HINCKLEY NATIONAL RAIL FREIGHT INTERCHANGE

Appendix 14 - Gibbet Hill Mitigation Road Safety Audit Stage 1

Stage 1 Road Safety Audit
RESPONSE REPORT GIBBET HILL

Report Title:	Hinckley National Rail Freight Interchange – Stage 1 RSA Gibbet Hill
Document Number:	HRF-BWB-HGN-RSA-RP-CH-0007
Prepared By:	BWB Consulting Ltd
Overseeing Organisation:	National Highways
BWB Reference:	NTT2814

Drawing Title  
**JUNCTION 26 - GIBBET HILL  
 PROPOSED MITIGATION  
 (HNRFI ONLY)**

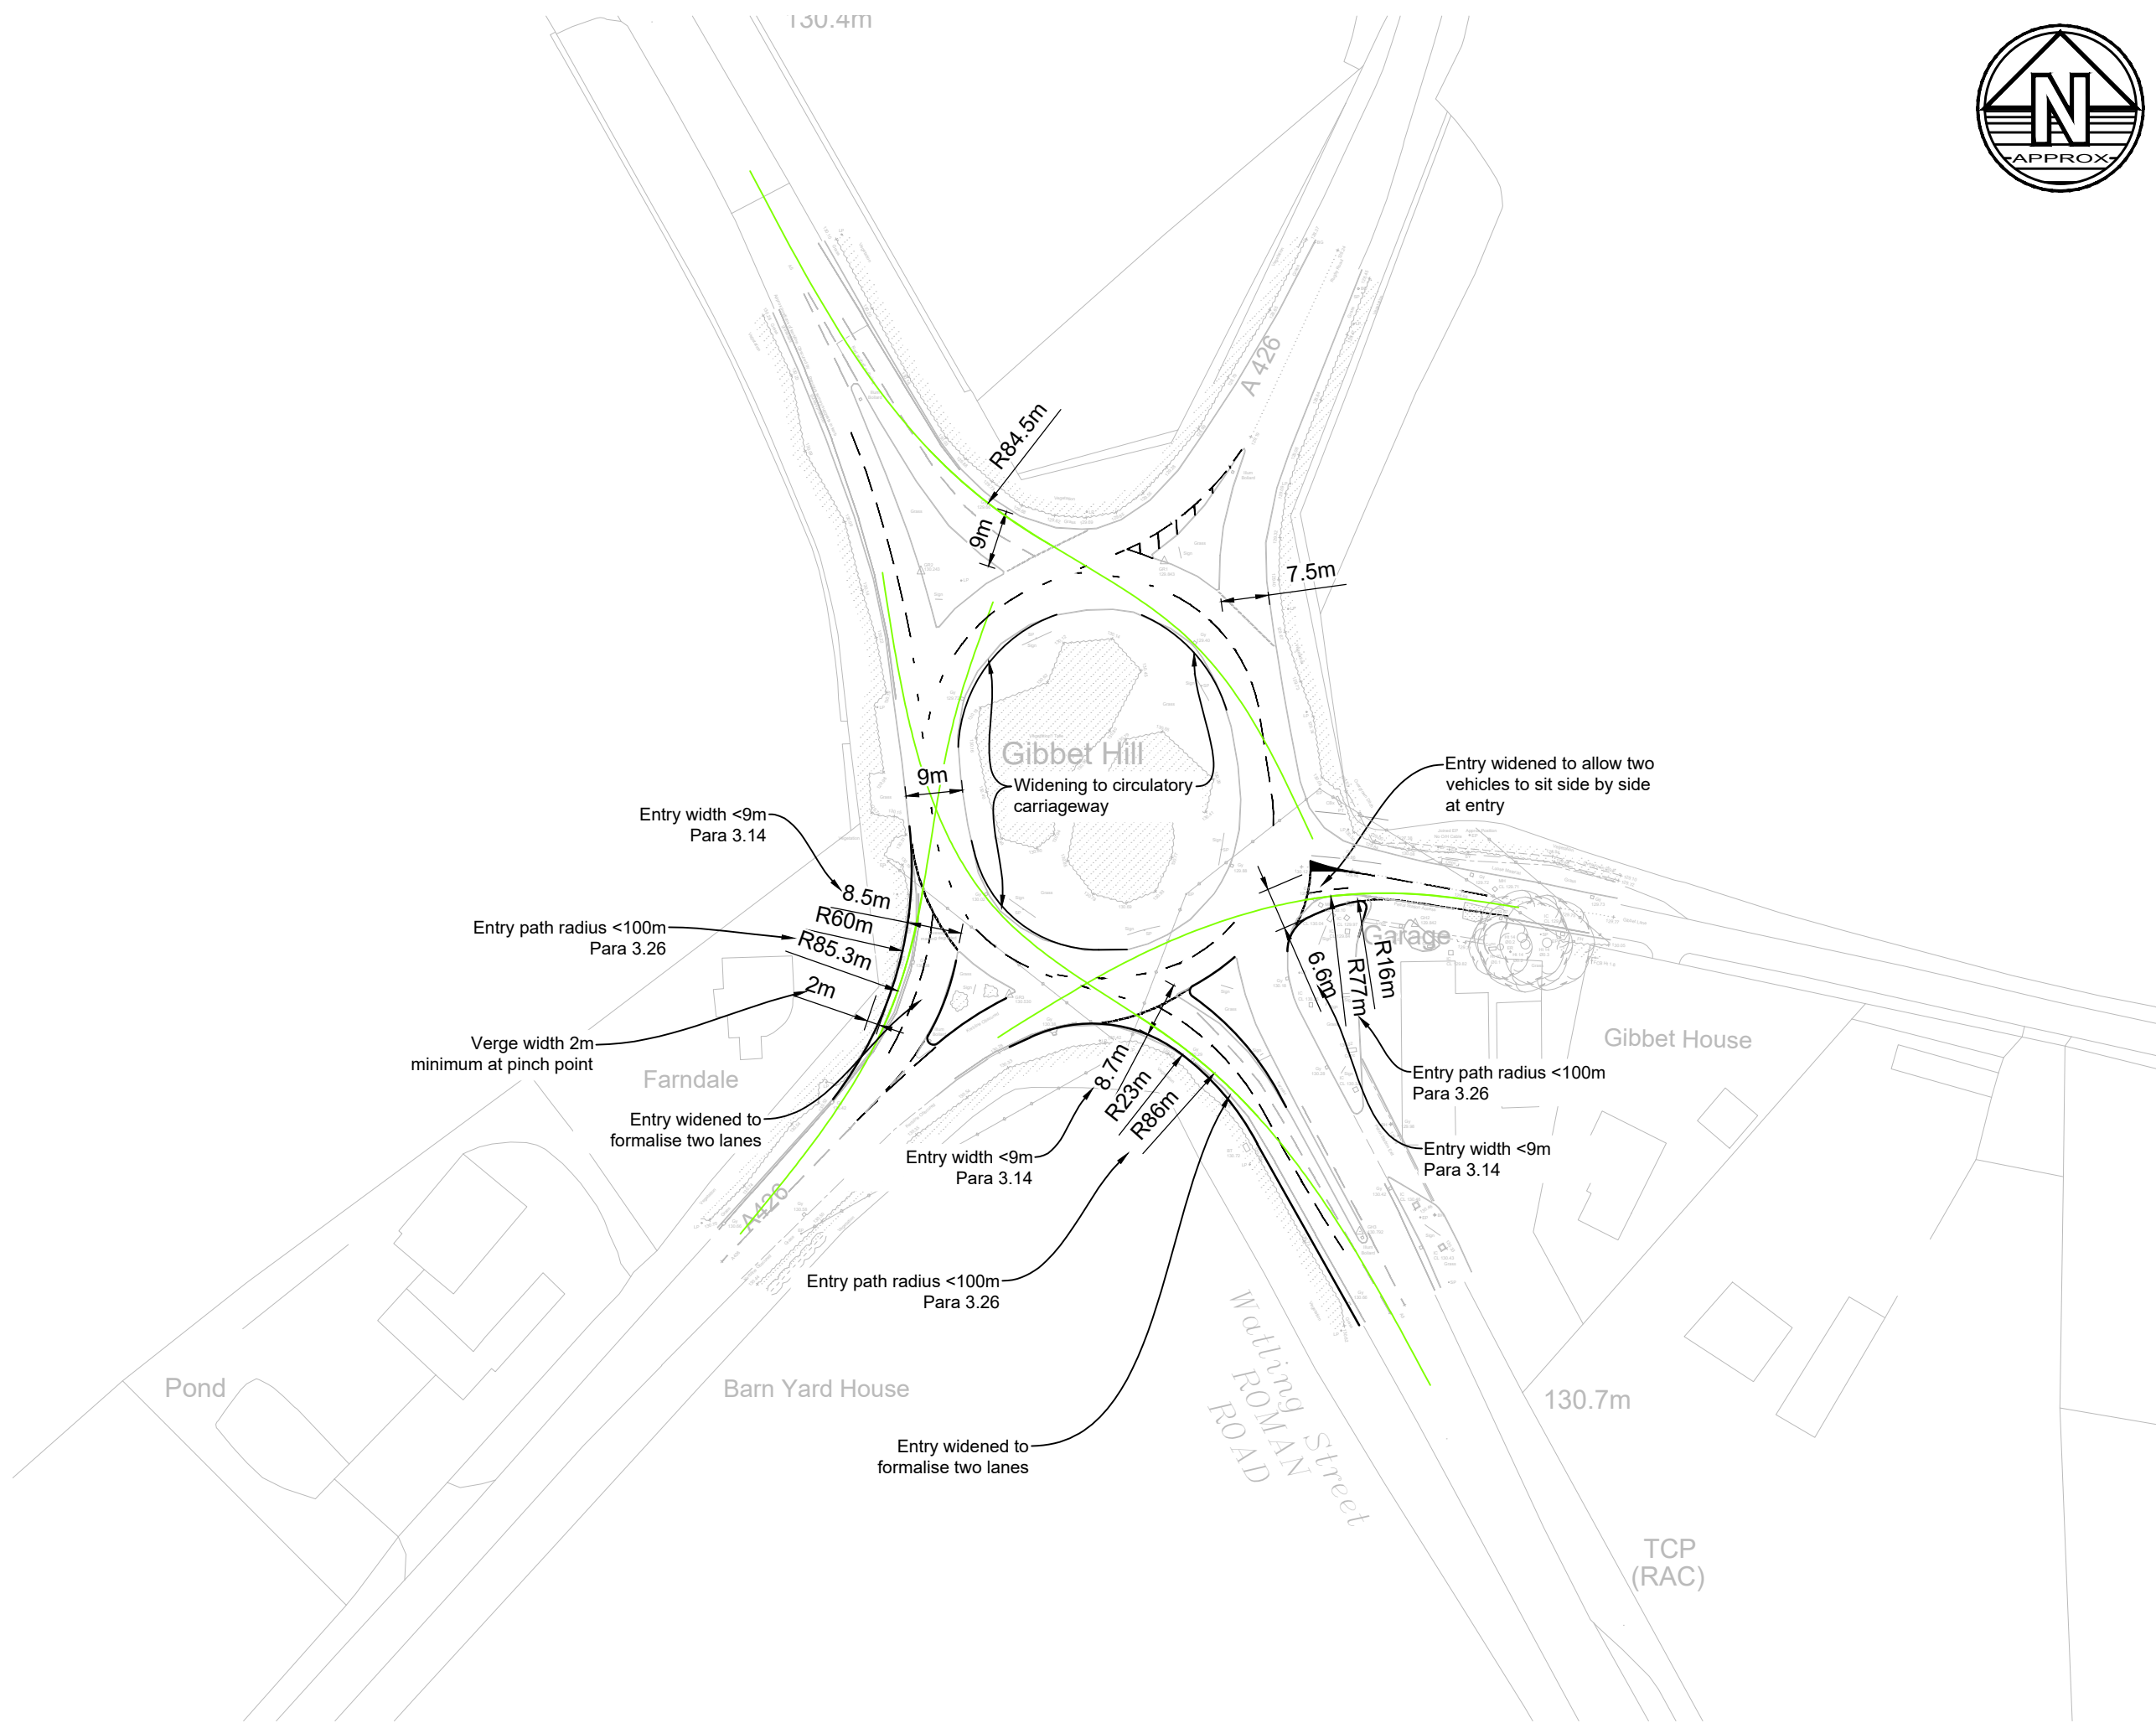
RSA Ref.	RSA Problem and Recommendation	Design organisation response	Auditor Response	Agreed RSA action
2.1	<p>Location: A426 northeast bound entry Summary: Potential elevated entry paths due to the relaxed kerb radius leading to loss of control</p> <p>The audit team is concerned with the proposed nearside kerb line on the A426 entry. The increased entry path radius is likely to impact on the entry speeds of vehicles using the roundabout. Reducing the entry path deflection leads to elevated vehicular speeds on entry which in turn could lead to loss of control collisions at the roundabout.</p> <p>Recommendation Review the proposed deflection in the nearside lane to ensure that the proposed entry path radius is not detrimental to entry speeds.</p>	<p>Agree with RSA Recommendation: Yes</p> <p>The entry path deflection is shown on the revised drawings and is compliant with CD 116 at < 100m.</p>

RSA Ref.	RSA Problem and Recommendation	Design organisation response	Auditor Response	Agreed RSA action
2.2	<p>Location: General to the scheme</p> <p>Summary: Potential loss of control resulting from ineffective drainage and associated ponding within the carriageway.</p> <p>There are various locations around the roundabout where there is significant vegetation and debris established in the channel lines of the carriageway which indicates likely ineffective drainage. If the drainage at and around the junction does not operate effectively there is an increased risk of surface water ponding which in turn could lead to loss of traction and loss of control, particularly in periods of freezing weather.</p> <p>Recommendation</p> <p>Review the drainage at the junction and revise as part of the scheme.</p>	<p>Agree with RSA Recommendation: Yes</p> <p>The drainage will be reviewed in detail at the detailed design stage. Additional detail has been added to the drawings to set out the requirements for additional filter drainage and kerb drainage.</p>

RSA Ref.	RSA Problem and Recommendation	Design organisation response	Auditor Response	Agreed RSA action
2.3	<p>Location: General to the scheme</p> <p>Summary: Potential collisions associated with insufficient circulatory width</p> <p>The formalisation of the two lane entries from A5 northbound, A426 eastbound and Gibbet Lane is likely to increase the occurrence of vehicles, particularly HGVs, using the circulatory carriageway two abreast. While the swept path drawings supplied to the RSA team suggest that this is achievable, site observations showed that there is evidence of significant overrun of the central island kerb line (on both the west and east sides) suggesting that there is insufficient width on the circulatory to safely accommodate two HGVs. This is compounded by the lack of road markings on the roundabout circulatory and all exits from the roundabout are single lane. Collectively this could lead to an increase in collisions on the circulatory, and side swipe collisions at the exits as two vehicles attempt to leave the roundabout at the same time.</p> <p>There is also a risk of an increase in HGVs overrunning the verge and central island bringing mud onto the carriageway which is particularly hazardous for powered two wheelers.</p> <p>Recommendation</p> <p>Review the swept path at the junction taking into consideration what could be happening in reality at present at the roundabout and if necessary, revise the kerb lines around the circulatory to ensure sufficient width is provided as part of the scheme.</p>	<p>Agree with RSA Recommendation: Yes</p> <p>Swept paths have been rerun and the roundabout circulatory carriageway has been widened in a number of places where vehicle overrunning is a risk in order to provide sufficient space between swept paths. New road markings on the circulatory carriageway are proposed to guide vehicles to the correct destination and mitigate the risk of vehicle overrunning or conflict.</p>

RSA Ref.	RSA Problem and Recommendation	Design organisation response	Auditor Response	Agreed RSA action
2.4	<p>Location: General to the scheme Summary: Potential collisions resulting from a lack of road markings</p> <p>There is a general lack of road markings on the approaches to and exits from the roundabout. Increasing the number of entry lanes in turn increases the number of vehicles on the negotiating the roundabout at any one time. Many of the users will be unfamiliar with the area and the lack of road markings could lead to incorrect positioning resulting in late lane changes or hesitation which in turn could result in collisions.</p> <p>Recommendation Provide sufficient road markings on approach to, exits from and on the circulatory of the roundabout.</p>	<p>Agree with RSA Recommendation: Yes</p> <p>New road markings have been proposed throughout the junction to ensure that vehicles are in the correct lane and to mitigate the risk of conflict.</p>

RSA Ref.	RSA Problem and Recommendation	Design organisation response	Auditor Response	Agreed RSA action
2.5	<p>Location: Areas of carriageway widening – A426 and A5 northbound entry</p> <p>Summary: Potential collisions with street furniture</p> <p>The localised widening and formalisation of two lane entries at the A426 and A5 reduces the offsets to street furniture and assets located within the nearside verges. At the A5 northbound entry, it was also noted that there is a level change towards the back of the verge to the land adjacent. In the event of a collision in these locations there is an increased risk of an errant vehicle colliding with street furniture or entering the adjacent field all of which will result in increased severity of injuries to vehicle occupants.</p> <p>Recommendation</p> <p>Assess the need for relocation of street furniture or the need for protection using VRS, by undertaking a RRRAP assessment.</p>	<p>Agree with RSA Recommendation: Yes</p> <p>Additional detail has been added to the drawings regarding existing street furniture and the treatment thereof. Any street furniture in conflict with the works would be relocated and a RRRAP assessment would be undertaken at detailed design as recommended.</p>
